RE: Crushe LLC Boundary Line Adjustment, BL-12-00001

Community Development Services is in receipt of the above referenced application and subsequent recorded survey identifying the proposed lot configuration. The application has been deemed complete but must be denied as submitted under provisions of Kittitas County Code 16.06.020(3) which reads as follows:

**RECORD OF SURVEY**  
 A PORTION OF THE SOUTHEAST 1/4 OF SECTION 1 &  
 A PORTION OF THE NORTHEAST 1/4 OF SECTION 12,  
 TOWNSHIP 20 NORTH, RANGE 13 EAST, W.M.  
 KITITITAS COUNTY, STATE OF WASHINGTON

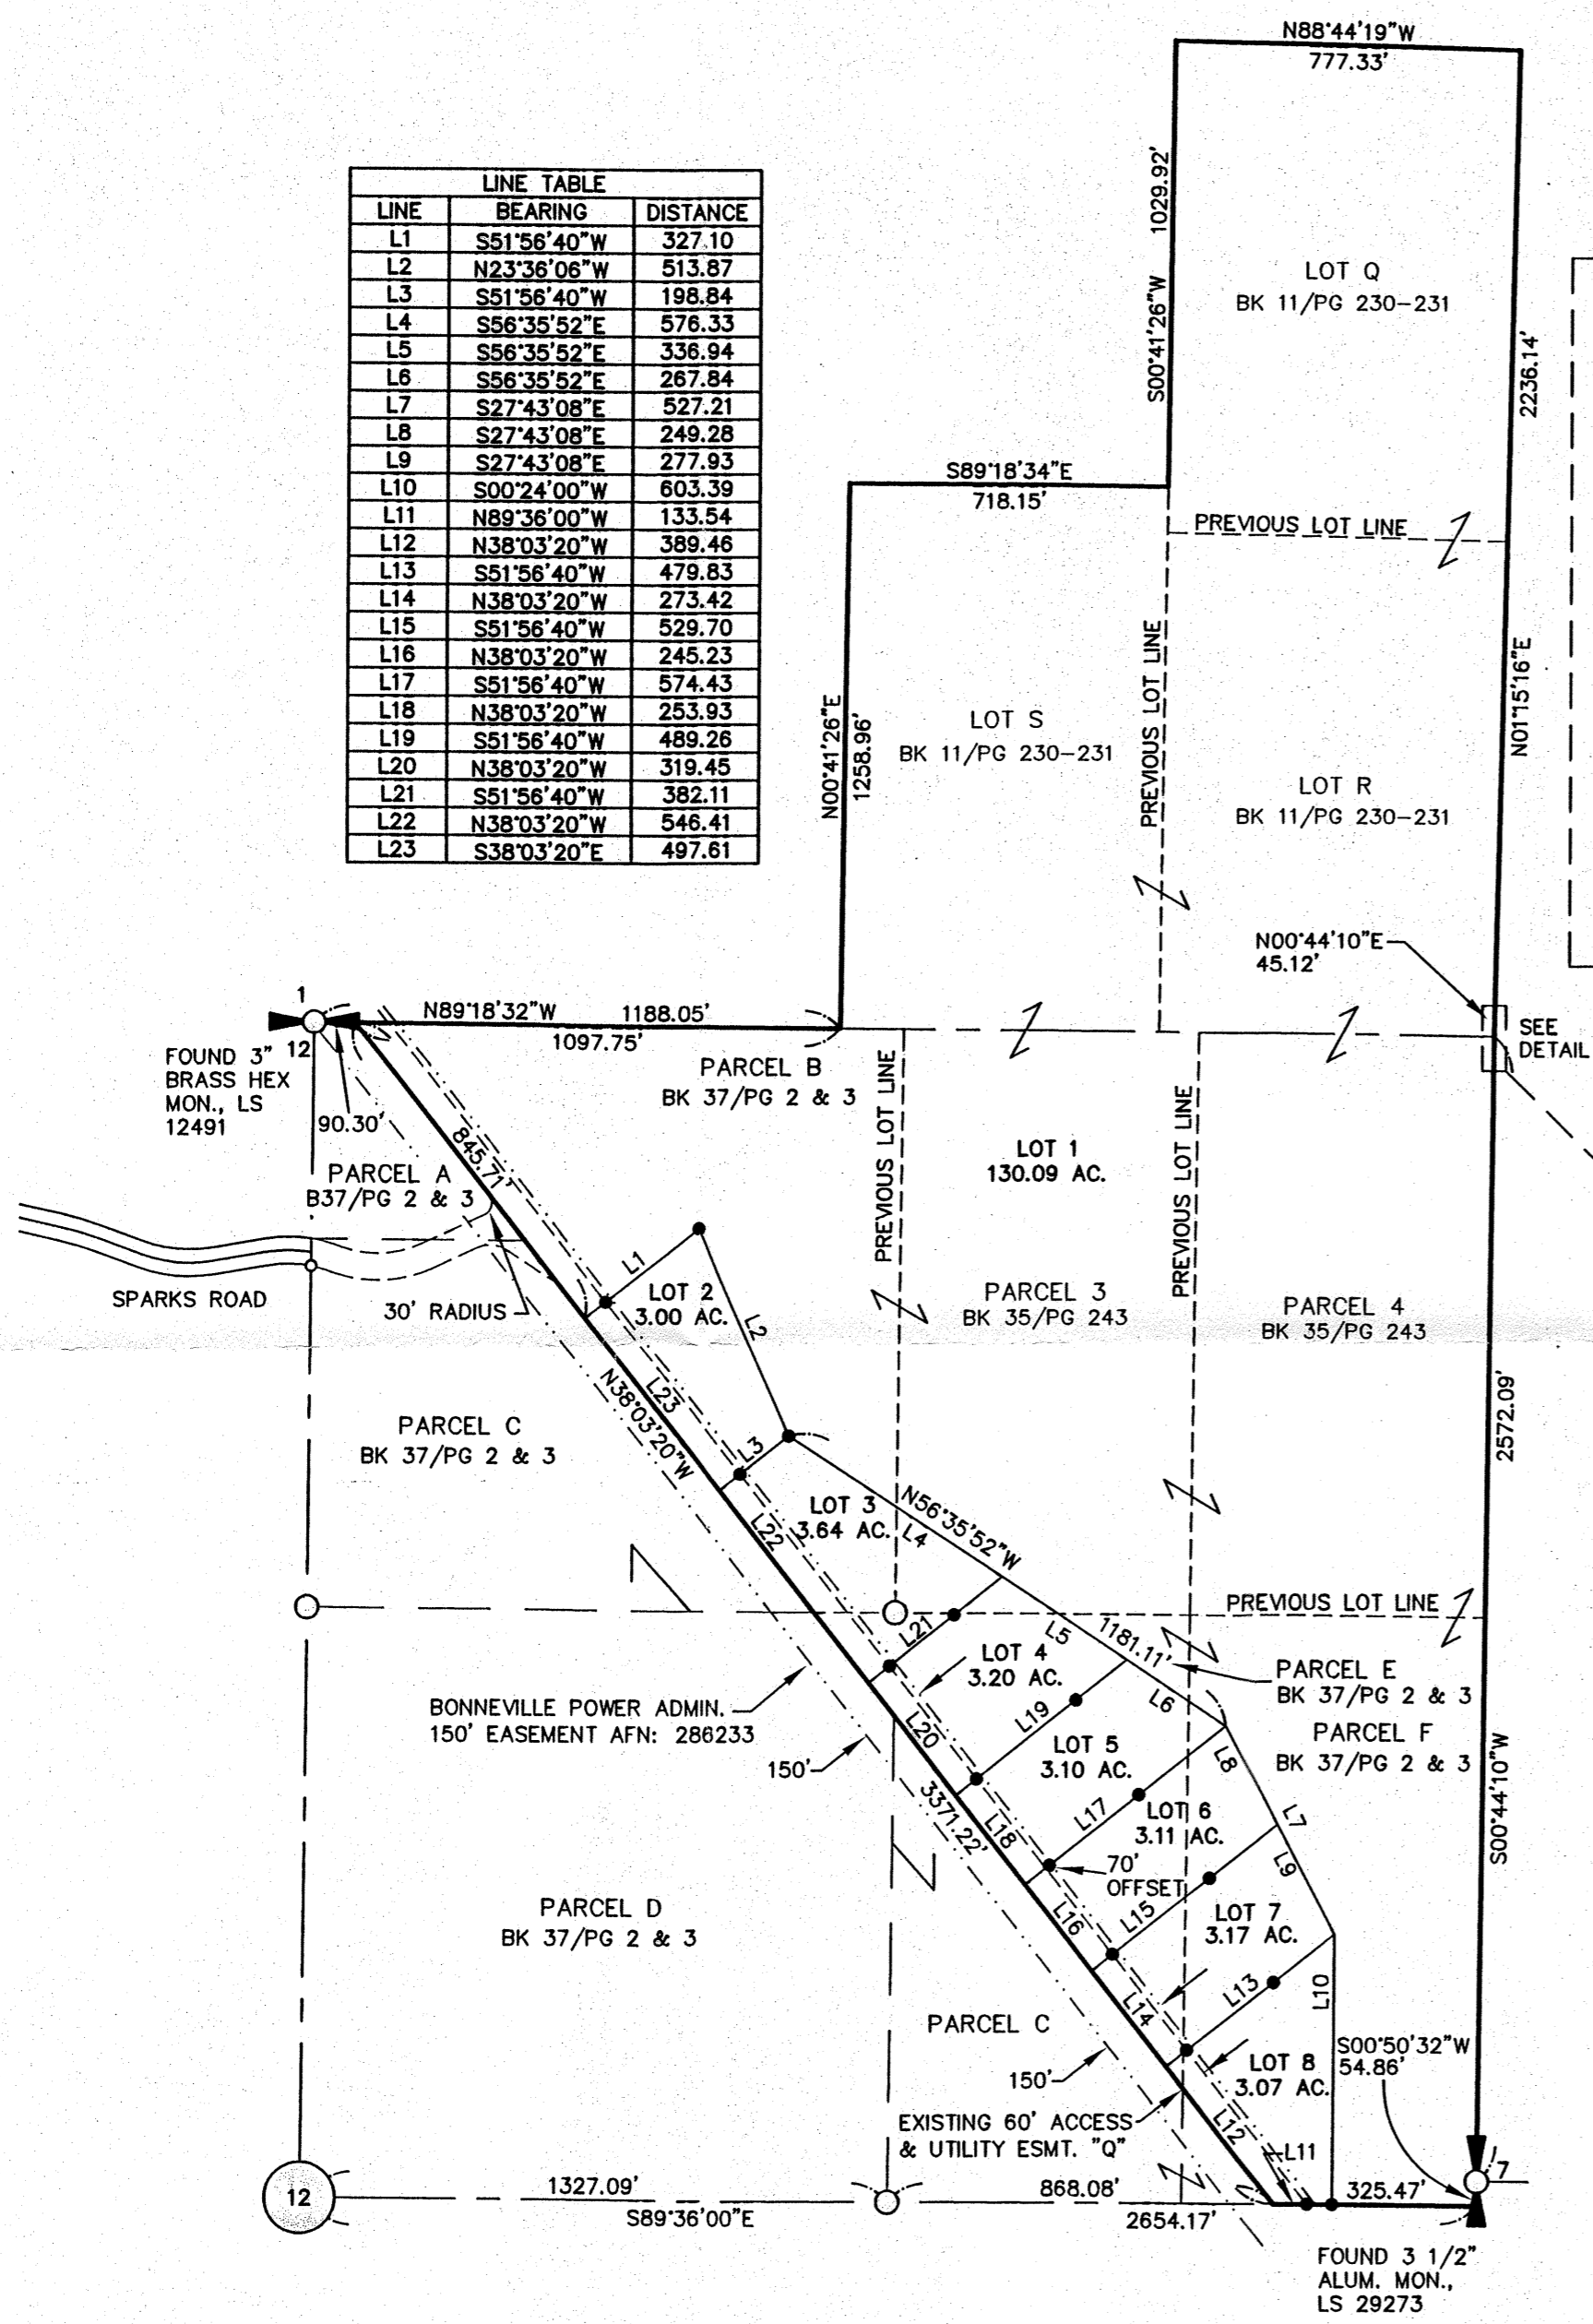
Five of the eight parcels (956225, 956226, 956227, 956228, 956229) involved in the proposed Boundary Line Adjustment were created through the Administrative Segregation process (SG-09-00001). In order for the reconfiguration to take place as proposed the Long Plat process would need to be utilized and approved as per KCC 15A and 16. This application, if reconfigured in some manor so that only the three parcels created through the Large Lot Subdivision process (956207, 956208, 956209) are reduced below the 20 acre threshold, may be reconsidered. Alternative proposals depending upon the number and characteristics of the parcels involved may require other processes.
